**Consultation Response from Mike Hibbert,
 KC Waste Strategy(Refuse & Recycling)**

2024/93605 Land at, Main Avenue, Cowlersley, Huddersfield, HD4 5US

Erection of 57 dwellings with access from new through road connecting Main Avenue and Windsor Road, and associated works, including engineering and landscaping

Responding Ref: WPS 24-087

Scale @ A1	Date Created	Drawn	Checked
SHOWN	10/09/24	ST	JT
TPS Project Number	Revision		
P2445	A		
Drawing Number			
P2445 - T - 1002

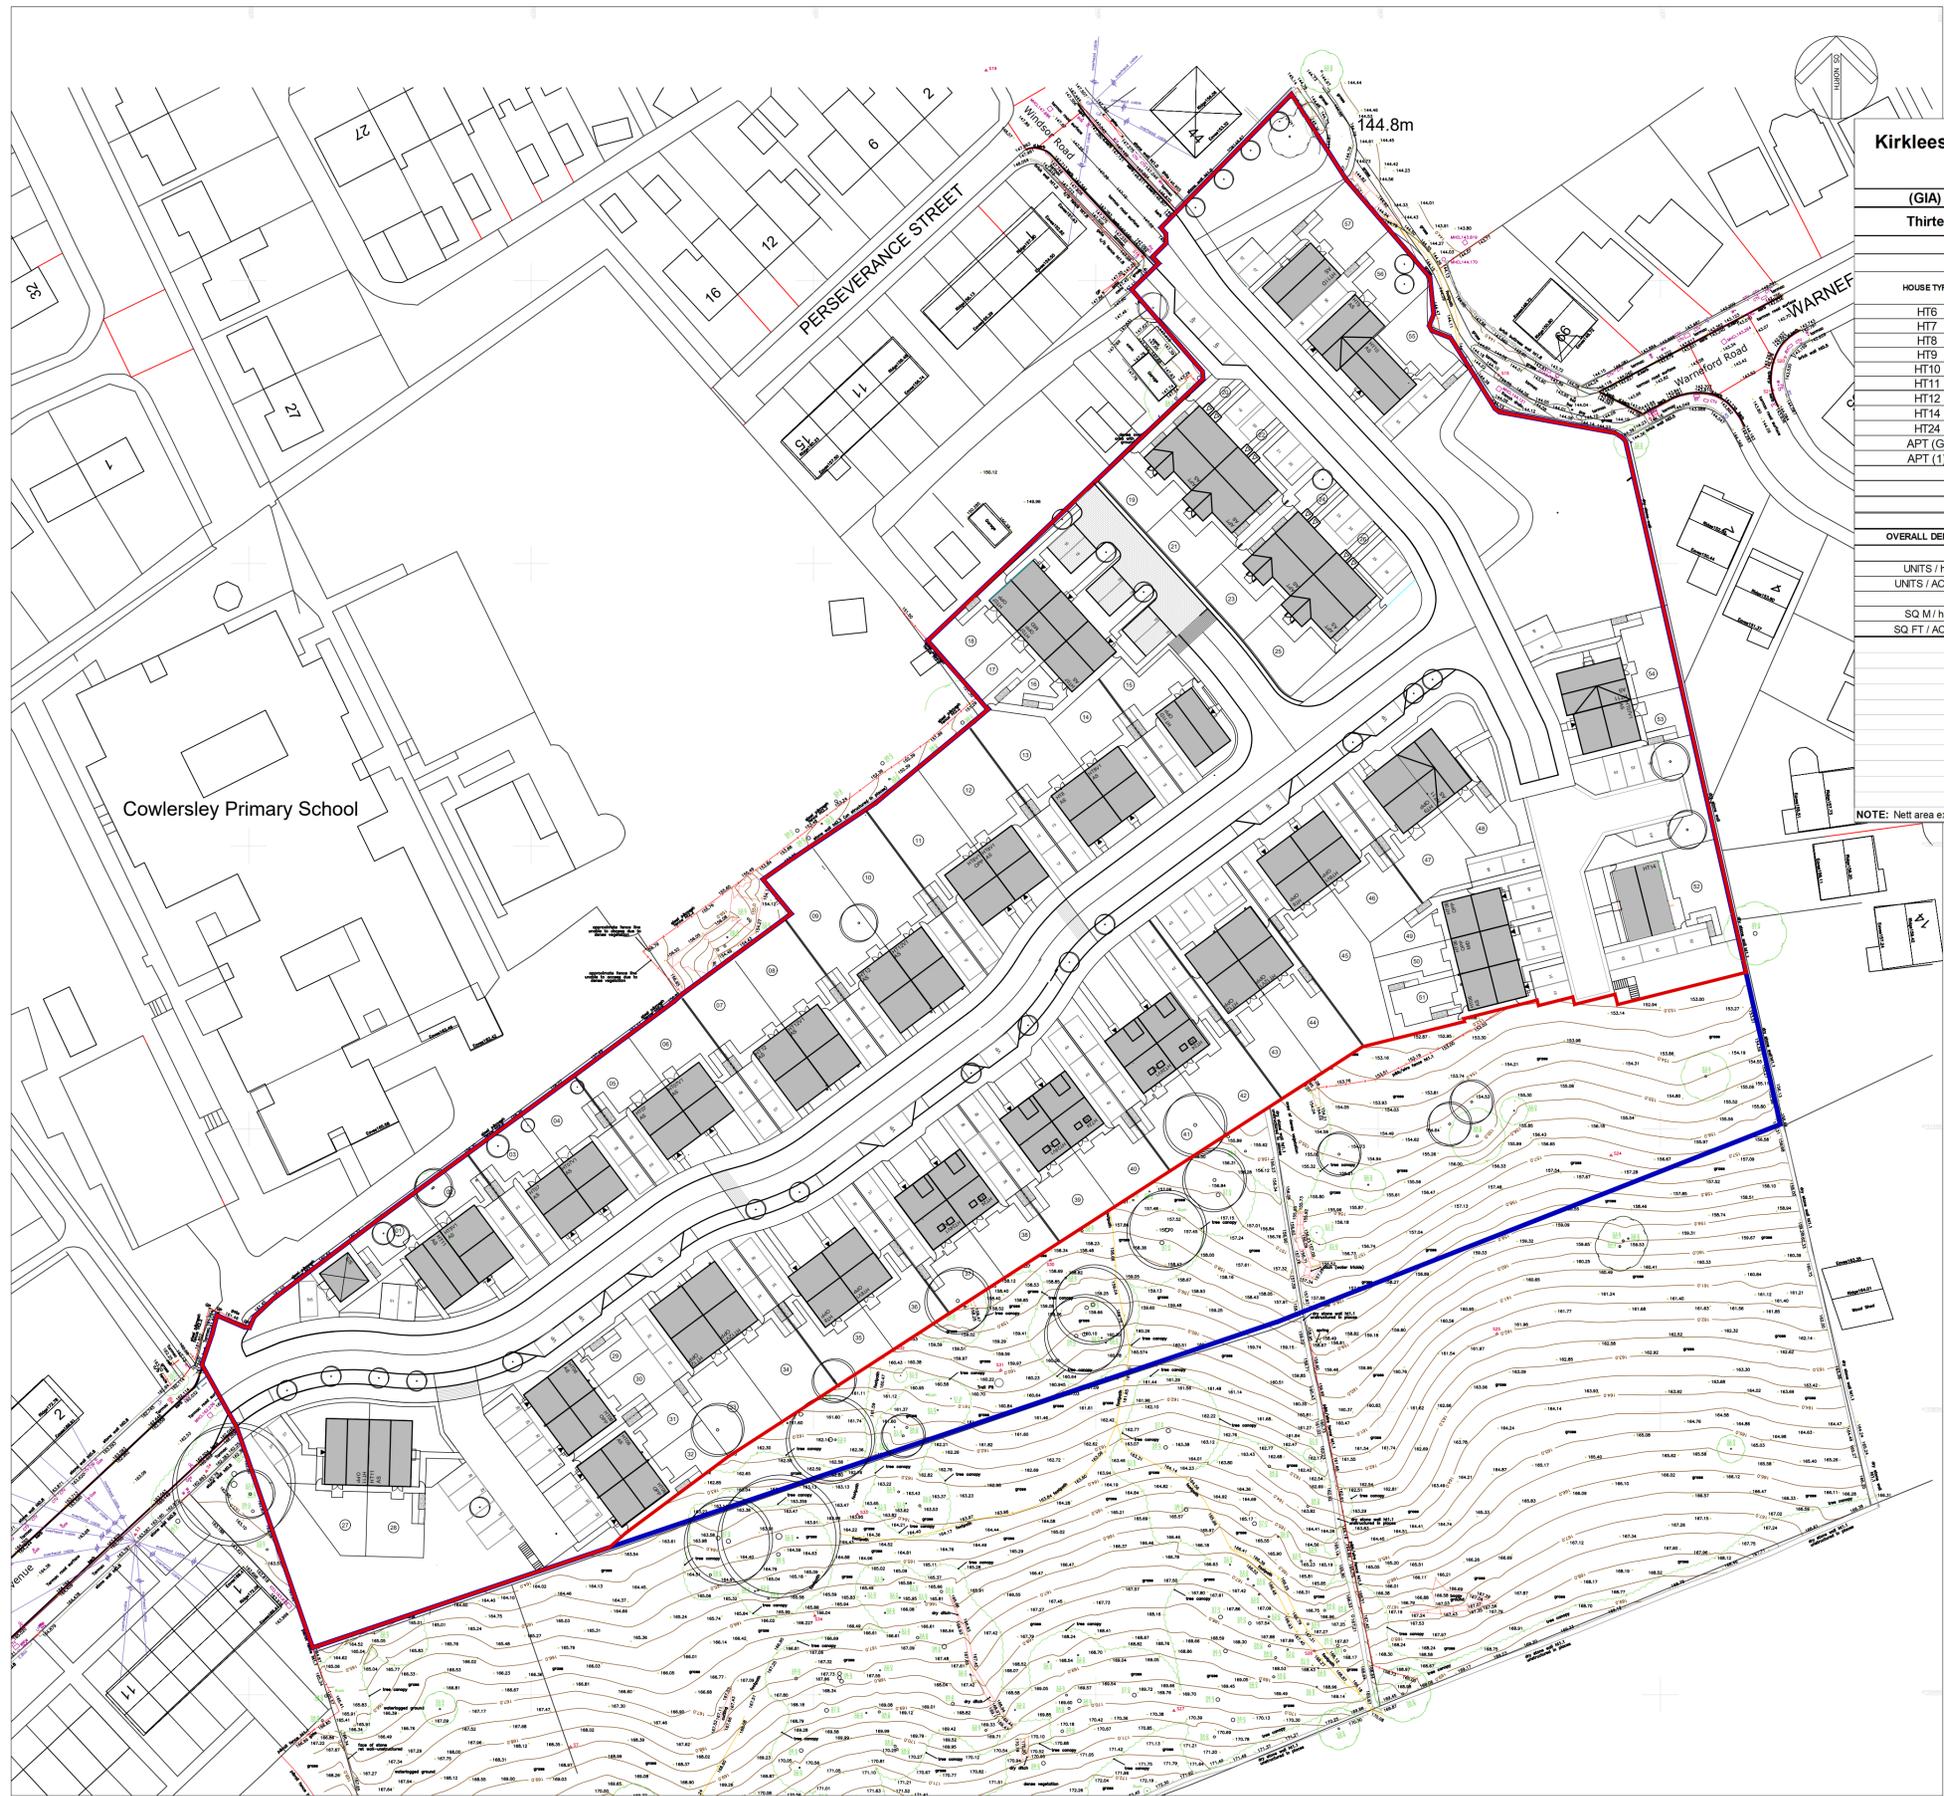
- Swept Path Analysis Drawing number P2445-T-1004 dated 18/10/24 shows routing for a 11.6m RCV. The current largest vehicle in the Waste Collection Authority fleet is 11.22m.

- Swept path analysis must show the manoeuvrability of this vehicle throughout the site, demonstrating the safe passing of other vehicles likely to be using the road – either parked or moving.

PROJECT / CLIENT Kirkless Cluster Sites Main Avenue Cowersley	PROJECT NO. N81-3084
ISSUANCE TITLE Proposed Materials and External Finishes Plan	DRAWING NO. 104
PROJECT LEADER GP	CHECKED BY IDP
DATE 22/10/2024	ISSUANCE P7

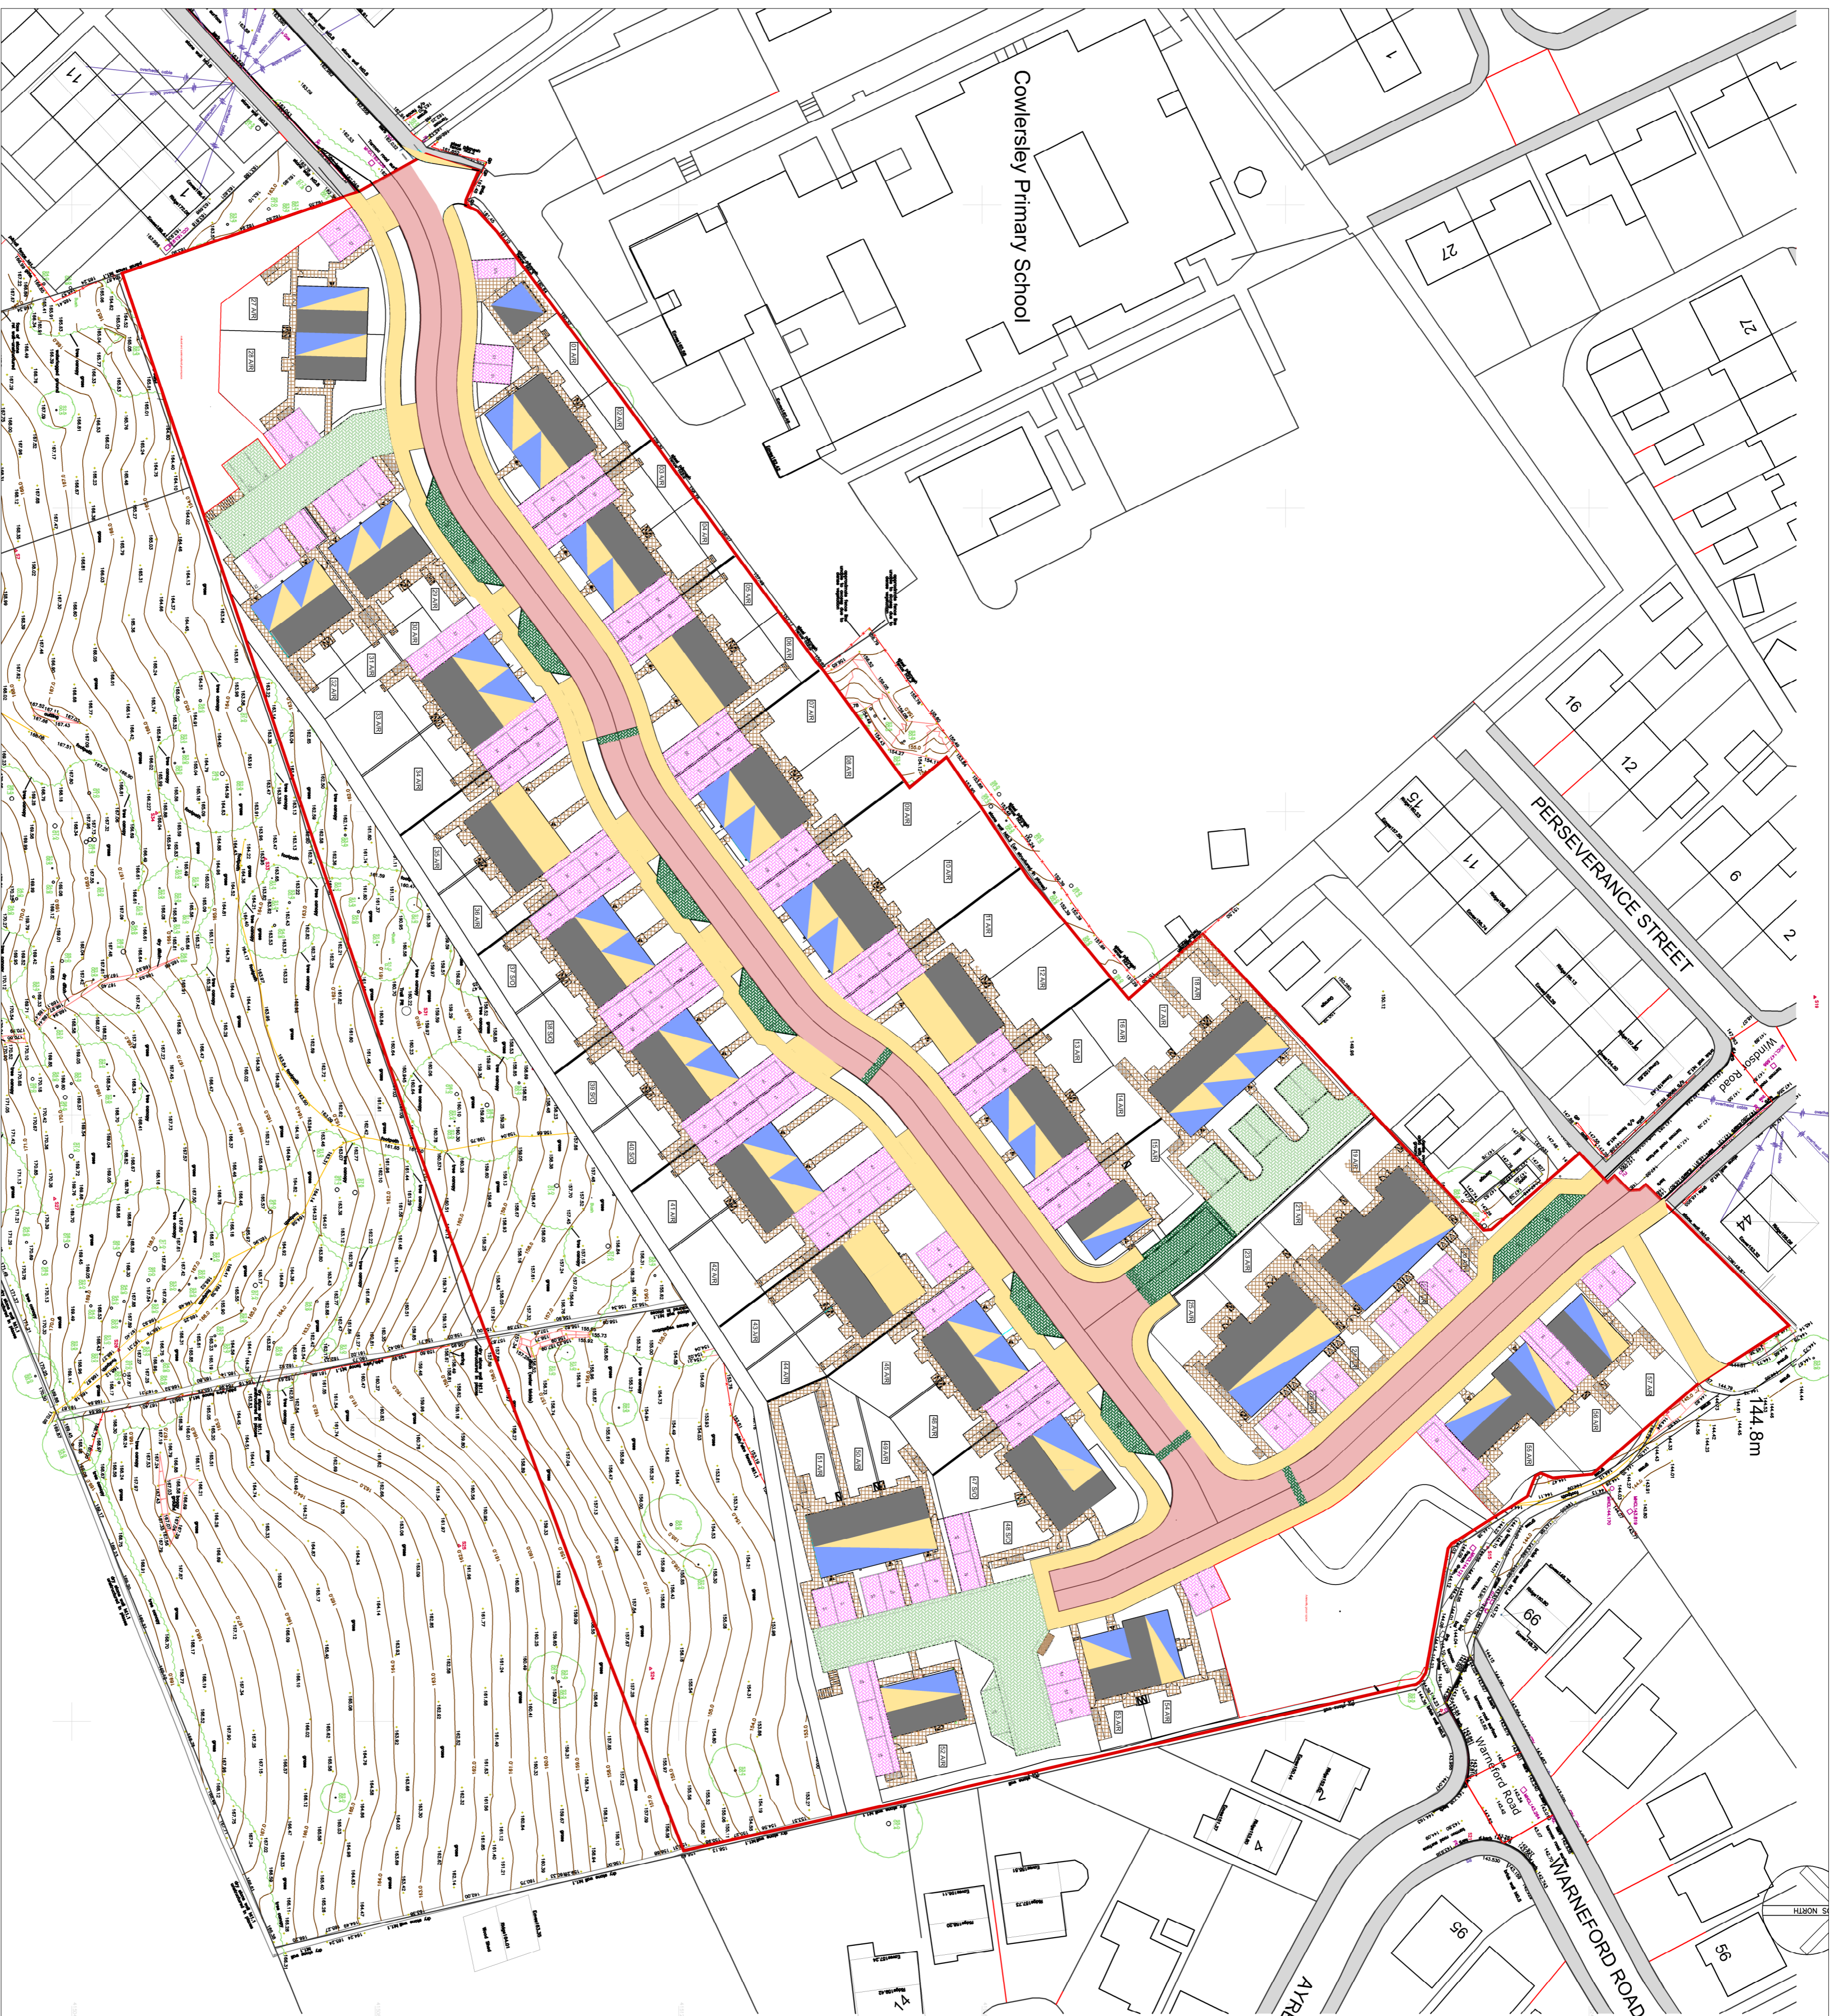
The applicant has submitted Proposed Site Layout Coloured Drawing Number 103 Rev P5 Dated 26.11.24. that is annotated with the proposed location of bin storage for three wheeliebins at each dwelling. This information is supported by the Design and Access Statement P1 17/12/2024 that in Section 4.3 Refuse Strategy and Cycle Storage outlines the Refuse Strategy Plan

- It is welcomed that the plan shows the storage for 3 x 240ltr bins at each property, 1x240ltr Residual, 1x240ltr Recycling and as the properties have gardens the space to accommodate a third bin for garden waste or to accommodate future changes to waste

- Preference is for storage of waste bins in rear gardens as shown on the plan. For plots where bin storage is in the rear gardens gated access should be secure, gates wide enough to pass through and the route between the rear gardens and the front access road must not require residents to pull bins up/down gradients of more than 1:12. Plots 17 and 50 are in terraced blocks and have convoluted access to rear gardens that may cause residents to leave bin on the frontage. Preference is for bin storage in rear gardens but consideration may need to be given to purposed designed bin stores to the front of the properties located away from windows and doors.

- The layout plan shows the location of communal Bin Collection Points (BCP's) for presentation of wheeliebins adjacent to the adopted highway for Plots 16 to 18 & 21, 29 to 32 and 49 to 52. The layout appears to follow guidance BS5906:2005 that specifies that the maximum drag out distance from an individual property to the Bin Collection Point (BCP) is 25m.

- It is welcomed that space for the presentation of bins on collection day is indicated on the plan. It is important to ensure that bins do not cause obstruction to pedestrians or other highway users when presented for collection, particularly where space requires these to be left in clusters. Bin presentation space should be on a hard surface and where a refuse collection vehicle (RCV) can be easily reached.

- To facilitate loading of full wheeliebins the surface between the bin store/ BCP and the highway should be smooth hard surface without kerbs. The proposed layout must ensure that parked cars do not obstruct the route between the bin store and loading point.

- The Authority will not take an RCV into private drives or roads that are not built to adoptable standards. Where the Plan shows shared surface streets, confirmation is sought these are adopted/ constructed to adoptable standard.

- Bin Collection Points are located on spur roads that service Plots 16 to 18 & 21, 29 to 32 and 49 to 52. Reversing is a recognised safety risk for crews and pedestrians. **The Waste Industry Safety and Health (WISH) Forum guidance states “Reversing causes a disproportionately large number of moving vehicle accidents in the waste/recycling industry. Injuries to collection workers or members of the public by moving collection vehicles are invariably severe or fatal. BS 5906: 2005 recommends a maximum reversing distance of 12 m.**
